Submission No.			166	
Organisation Name or Name of Submitter			Leo and Anne Crehan	
Item No.	Section Ref.	Page No.	Observation Statement	TII Response
Re: Railway (Metrolink-Estuary to Charlemont via Dublin Airport) order 2022 Case Reference Number NA29N.314724				
1	Letter - Introduction	1	<p>We live at 11 Dartmouth Square West....</p> <p>Firstly, in general, we are in favour of the broad aim of the Metrolink project to connect Dublin's city centre to our national airport. However, as a resident living in the Dartmouth/Charlemont area, we wish to set out a number of observations for the Board regarding the proposal to locate the Terminus station at Charlemont-Dartmouth. Our family home is in the midst of the community where the Terminus station is proposed to be located; and further, the application makes provision for part of our property to become the subject of a Compulsory Purchase Order.</p> <p>We respectfully ask that you consider the following points in making your decision on the Application.</p>	<p>Thank you for taking the time to make a submission and your overall endorsement of the MetroLink Project. We have reviewed your submission and responded to the observations made

Figure 3.1: Proposed Site Access Arrangements

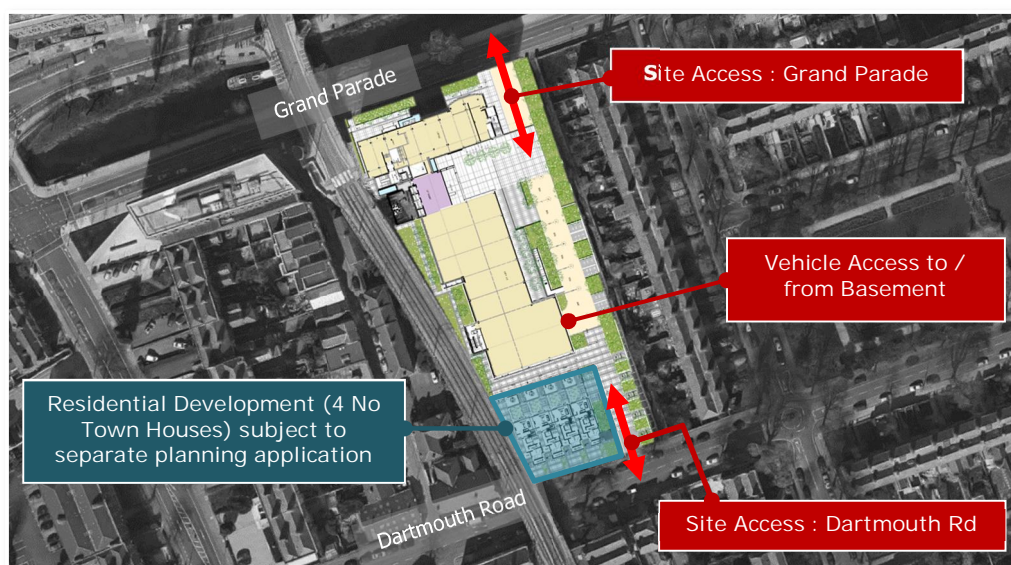
5	Letter - Point 3	2	3. The station box at Charlemont, as constructed in 2021/22 by the Developer Hines, does not have the benefit of planning permission and has not been part of the EIA undertaken for this project. Processing the current Railway Order application, which is reliant on these preliminary and now constructed works, is legally unsafe and contravenes the provisions of the EIA Directive.	The MetroLink enabling works constructed as part of the Hines development was included in the planning application for the Hines Development and has the benefit of planning permission which was granted in April 2019.
